**KIRKLEES METROPOLITAN COUNCIL
INVESTMENT & REGENERATION SERVICE**

DELEGATED DECISION TO DETERMINE PLANNING APPLICATIONS

Reference No:	2024/62/92859/E
Site Address:	40, Highfield Drive, Birstall, Batley, WF17 9BG
Description:	Removal of existing conservatory and erection of single storey rear extension, first floor side extension with carport underneath and detached garage with garden room, raised decking and external rendering to existing dwelling
Recommending Officer:	Faiza Bano

Client		Mr Wood & Ms Kaye	
Job		40 Highfield Drive Birstal	
Title		Proposed Side Elevation	
Drawn By	RK	Date	Aug 2024
Eng. Check		Scale	1:50
Tech. Check			
Drawing No.		Rev.	
2024 / 464 / 03

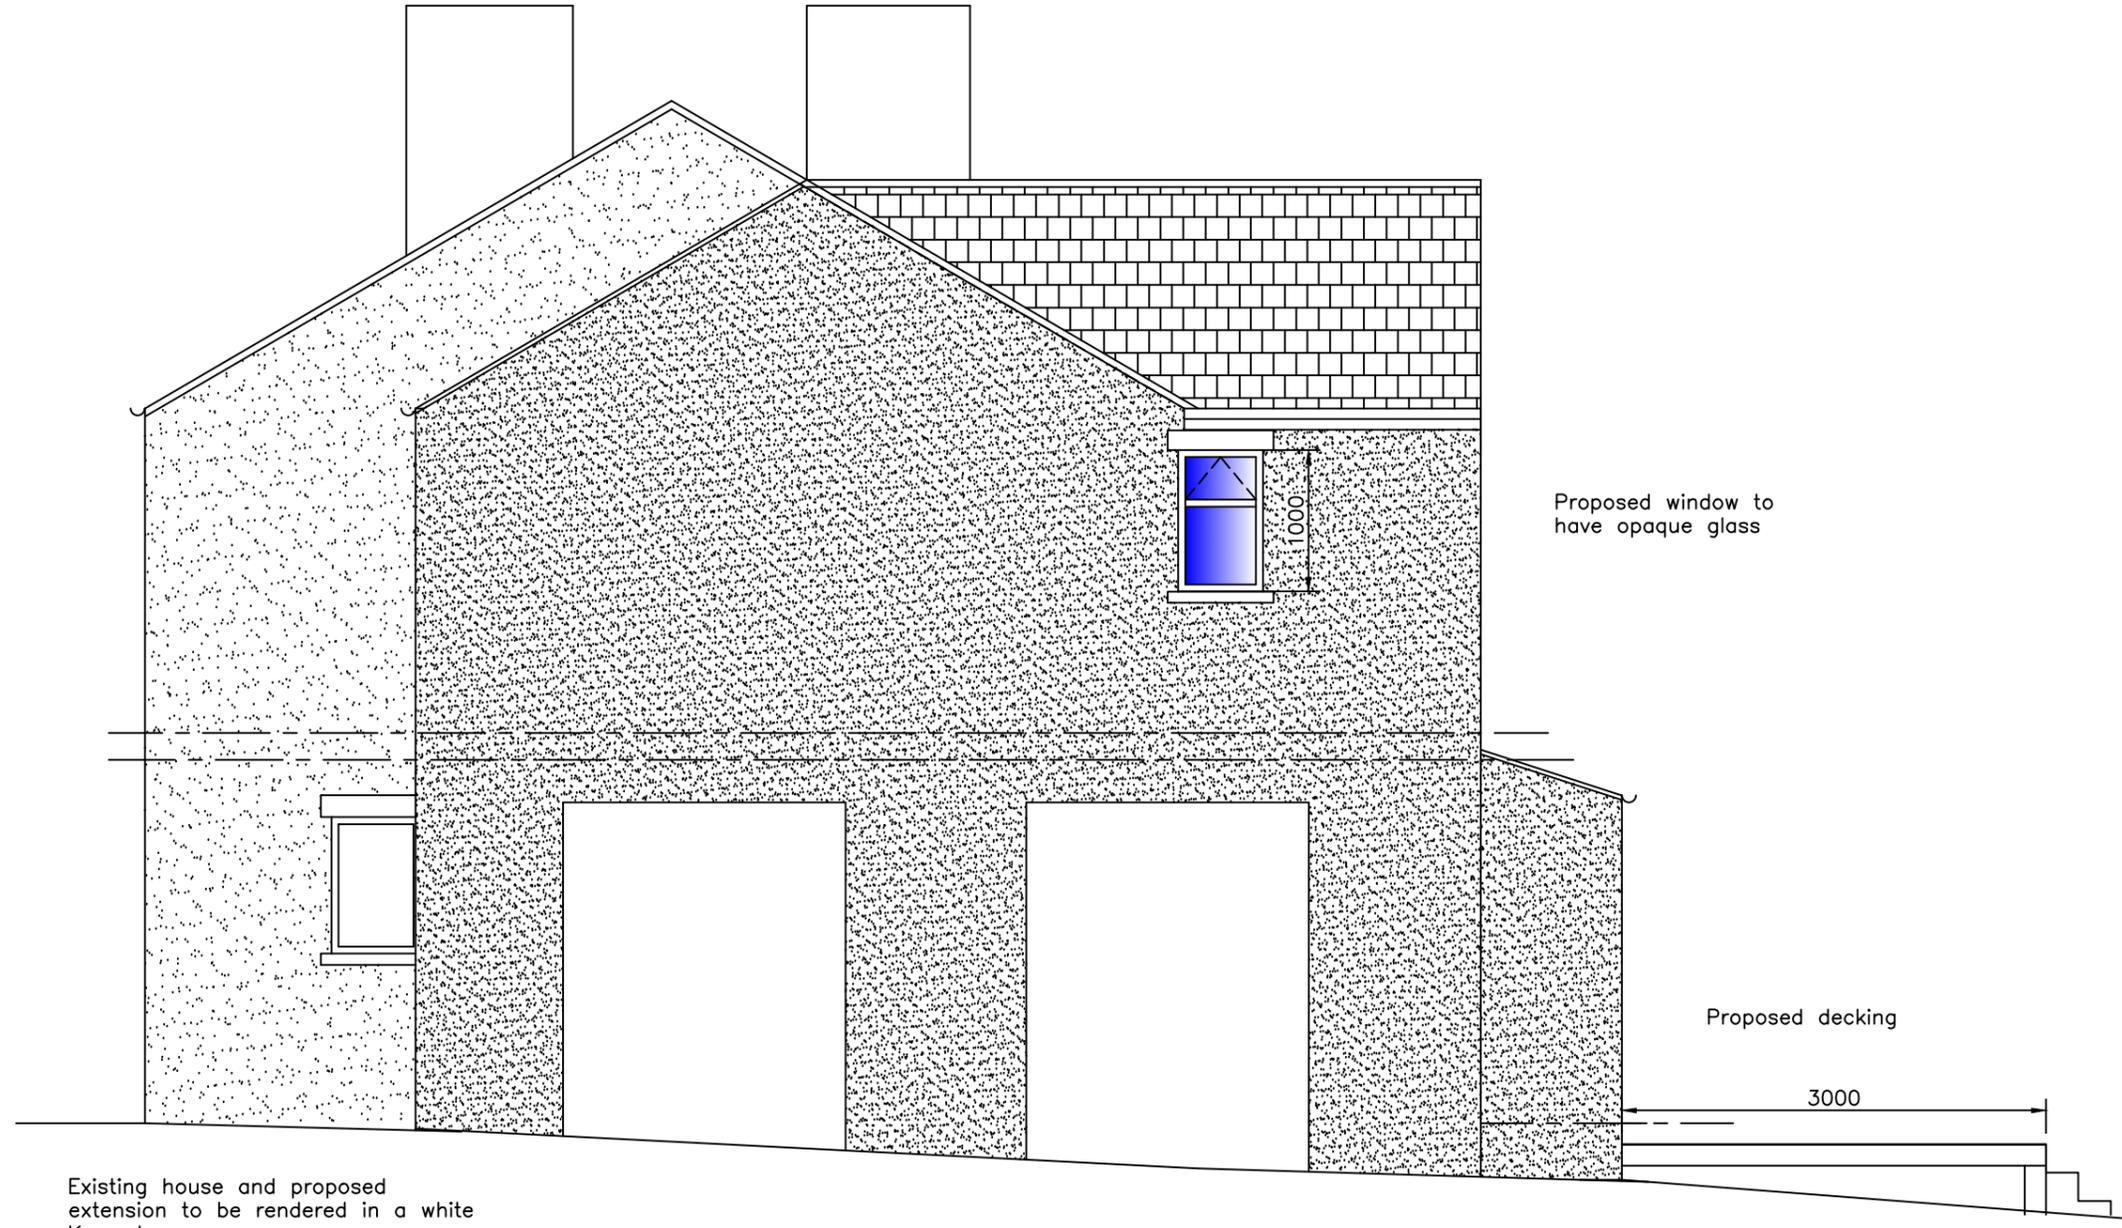
Two storey side extension

Paragraphs 5.15, 5.19, and 5.21 of the House Extensions & Alterations SPD are pertinent to the side extension. These guidelines stipulate that the proposed development should be positioned and designed to minimise its impact on the area's character, reflect the original building's materials and detailing, and ensure sufficient space is maintained to preserve a sense of space.

The proposed development honours the guidance from the SPD as it is set back and set down from the original building line and ridge. The proposed materials are white K-render and tiles – the application proposed that the original dwelling will be finished in K-render too and the proposed development would therefore match the existing. The attached semi is also finished in white K-render, the proposed development would therefore create a sense of harmony across the street scene. The proposal suggests tiles for the roof covering and the crossed gable end roof forms an appropriate relationship between the main house and proposed extensions. The side extension is therefore considered to be acceptable in terms of visual amenity.

The side extension would be located on the opposite side of the host property to the adjoining dwelling and as such would result in no overlooking, overshadowing or overbearing.

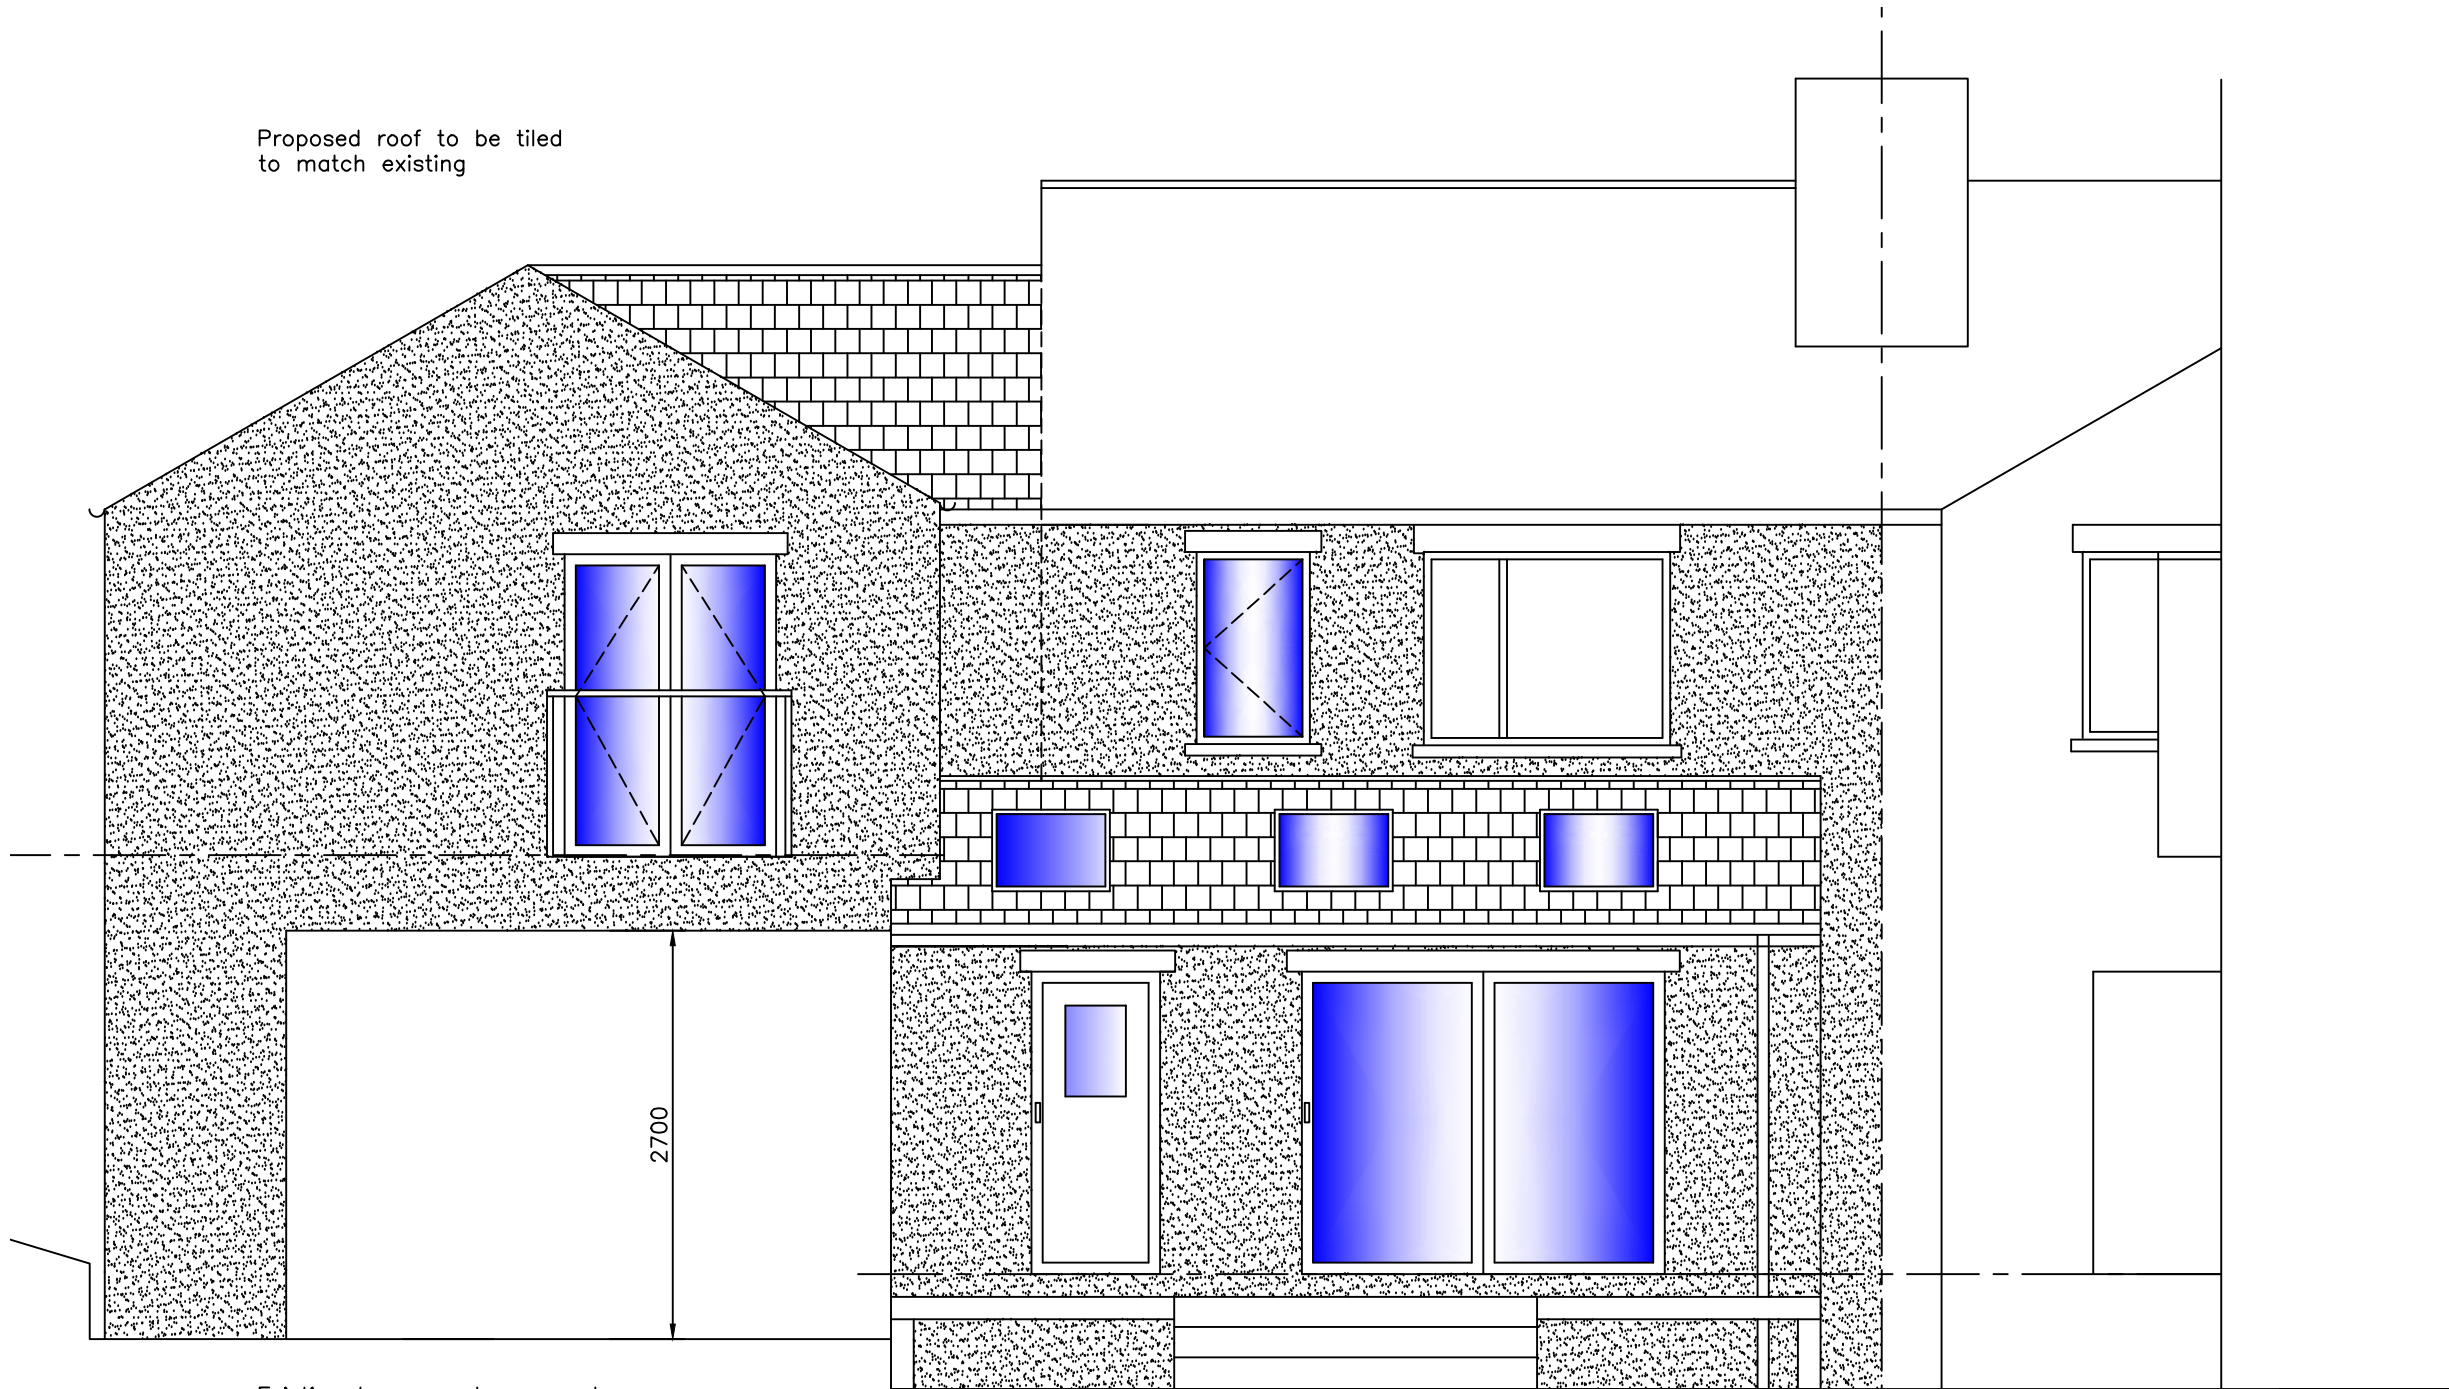
Single storey Rear Extension

Paragraph 5.1 of the House Extensions & Alterations SPD states that “*Rear extensions should maintain the quality of the residential environment and relate well to the neighbouring buildings. Rear extensions should generally not be visible from the street and should retain a reasonable living environment for the property being extended.*”

The rear extension is modest in terms of projection and is single storey and therefore, the scale is acceptable. The proposed materials are to match the

existing dwelling, which include a finishing of white K-render and tiles. The rear extension is therefore considered acceptable.

38 Highfield Drive – This property is the neighbouring semi-detached property. The proposed rear extension would have limited impact on this property as it replaces the existing conservatory and 38 Highfield Drive has an existing two-storey rear extension. The rear extension is limited in terms of its size and would have no potential to result in any significant overlooking, overshadowing or overbearing.

Client		Mr Wood & Ms Kaye	
Job		40 Highfield Drive Birstal	
Title		Proposed Garage Plans & Elevations	
Drawn By	RK	Date	Aug 2024
Eng. Check		Scale	1:100
Tech. Check			
Drawing No.		Rev.	
2024 / 464 / 07

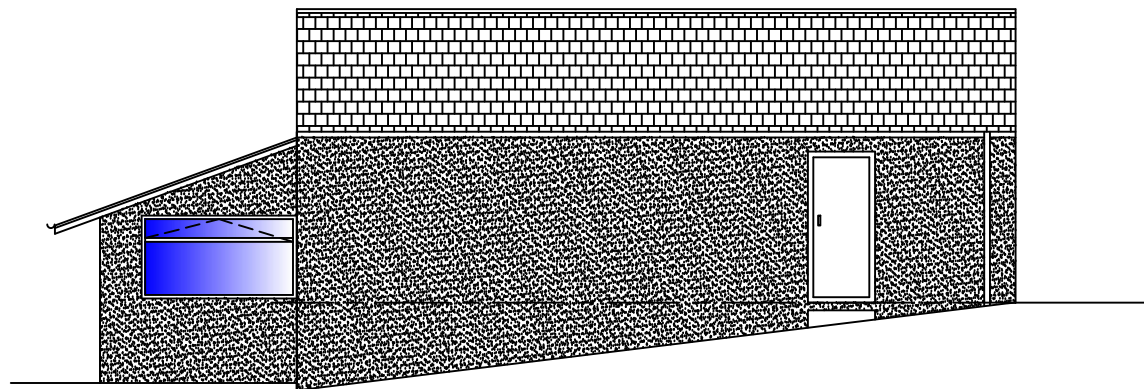
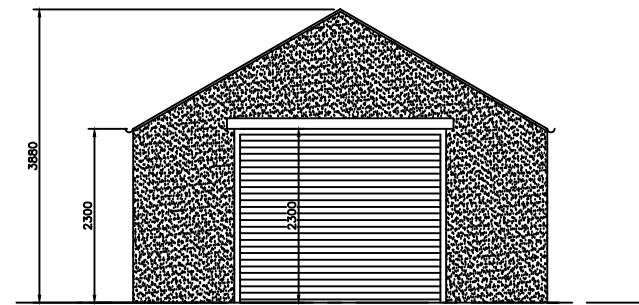
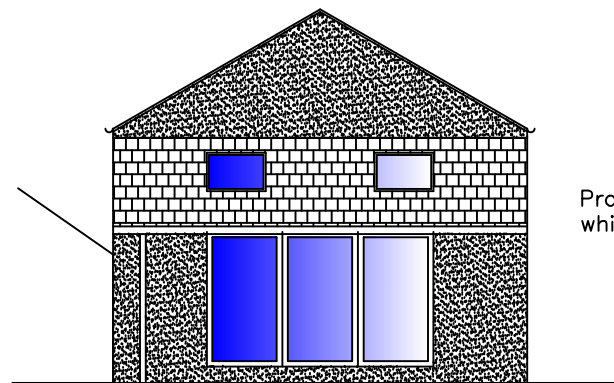
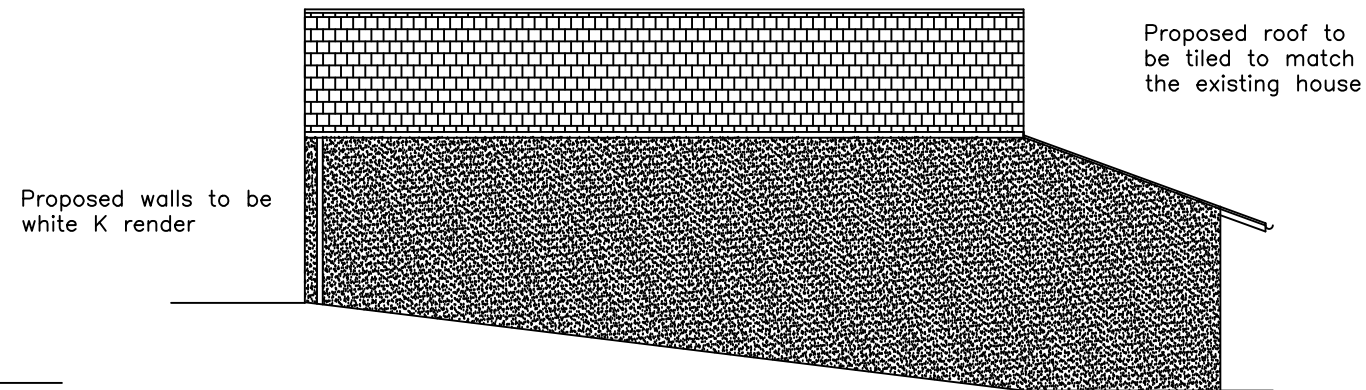
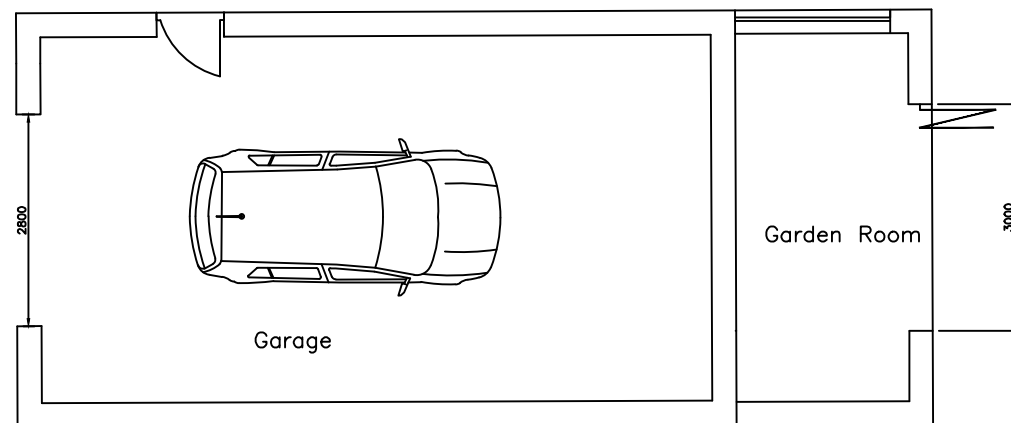
The proposed outbuilding would combine a garage and garden room. The outbuilding would be approximately 5.5 metres in width, 12.1 metres in length, have an eaves height of 2.2 metres and an overall height of 3.9 metres. The garage would feature a gable roof, and the garden room would feature a lean-to roof, with roof lights. The outbuilding would feature access in the form of a garage door to the front, access to the side and bi-fold doors to the rear as part of the garden room.

Paragraphs 5.29 and 5.30 of the House Extensions & Alterations SPD are pertinent to outbuildings. These guidelines stipulate that wherever possible; outbuildings should reflect the style, shape, and architectural features of the existing house without compromising the surrounding space. They must be subservient in scale to the original building and garden, considering other extensions and outbuildings. Additionally, they should be set back behind the original building line to avoid impacting the street scene and preserve adequate private amenity space, ensuring no more than 50% of the garden is lost.

The proposed outbuilding reflects the style, shape and architectural features of the original dwelling, it is modest in scale and is set back behind the original building line. The proposed outbuilding doesn't negatively impact the private amenity space of the dwelling and does not result in more than a 50% loss of garden space. The proposed outbuilding is therefore considered acceptable in terms of visual amenity.

The outbuilding would be located away from the shared boundary line of the adjoining dwelling and as such would result in no overlooking, overshadowing or overbearing. In order to protect the amenity of adjoining occupants permitted development rights are removed for future development.

Client		Mr Wood & Ms Kaye	
Job		40 Highfield Drive Birstal	
Title		Proposed Site Plan	
Drawn By	RK	Date	Aug 2024
Eng. Check		Scale	1:200
Tech. Check			
Drawing No.		Rev.	
2024 / 464 / 08

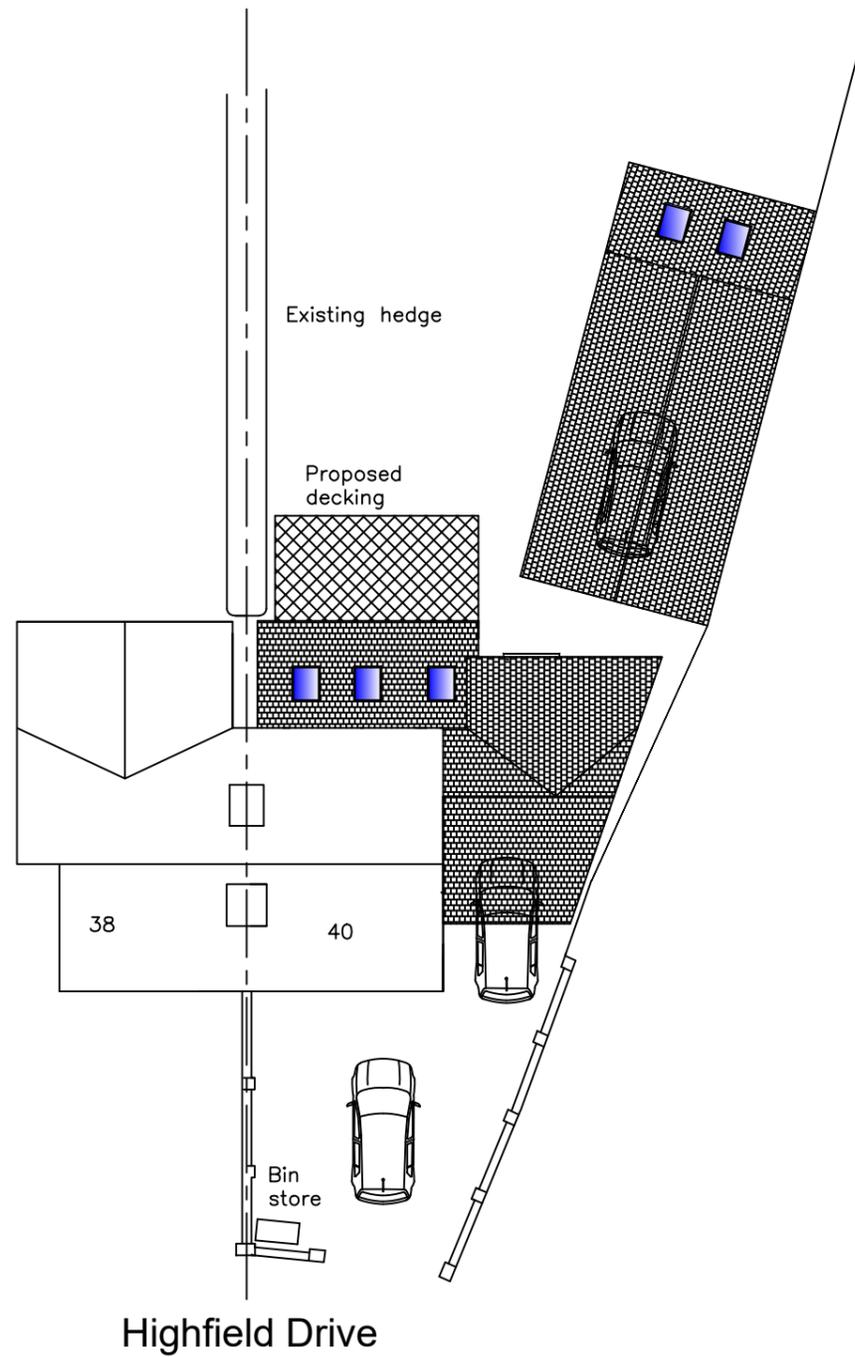
The proposals will result in some intensification of the domestic use. However, the property has a parking area to the front and rear. Furthermore, the car port element on the ground floor would allow for vehicle access. The parking for the property therefore has sufficient parking.
